Letter of Intent
Special Use Permit
Rural Home Occupation

Kesti Suggs executive owner of Chuckie’s Place, a non-profit corporation, DBA as Reigning Hope
14445 Holmes Road
Colorado Springs, CO 80908

The Request is for the approval of a structure variance to allow a 63 foot by 75 foot, 1 story structure.

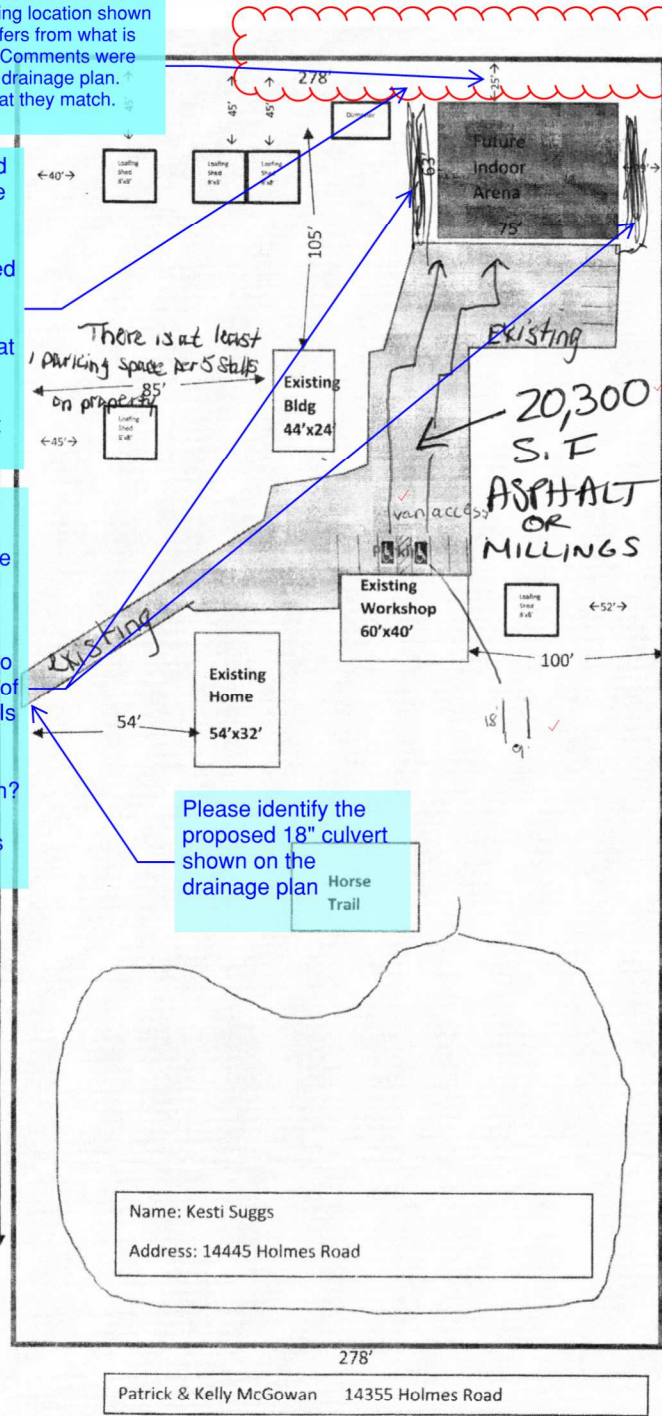
Please clarify if this paved driveway is new/proposed. Identify the total amount of land disturbance that is proposed. Note that if land disturbance is 1 acre or greater additional engineering documents will be required.

Please revise this last sentence to match what was provided in the letter of intent for the approved special use application(AL1815). That letter of intent stated: "No parking will be allowed on access road, north of the property, which is on the private drive on the Hoffman's Property."

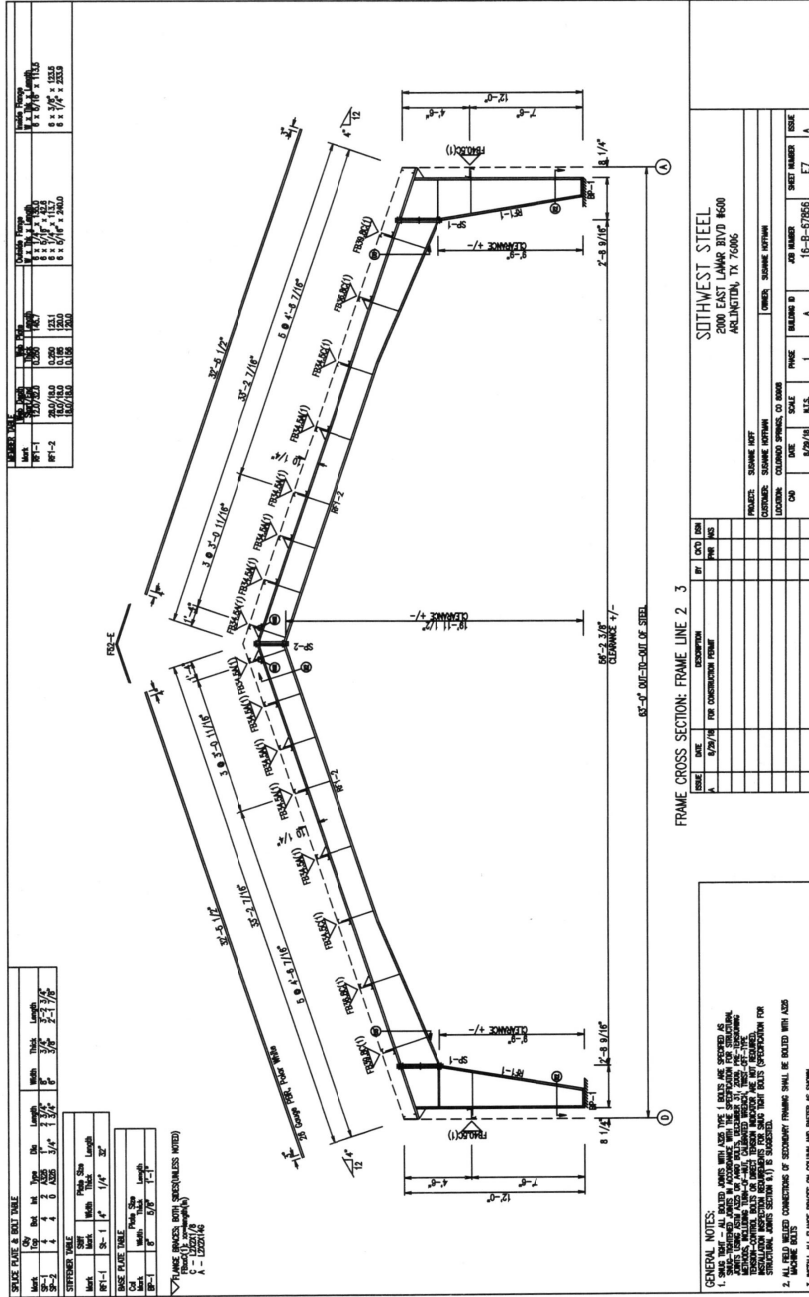
The letter of intent from the approved special use and the submitted site plan indicate 5 loafing sheds 8x8. Please list that here.
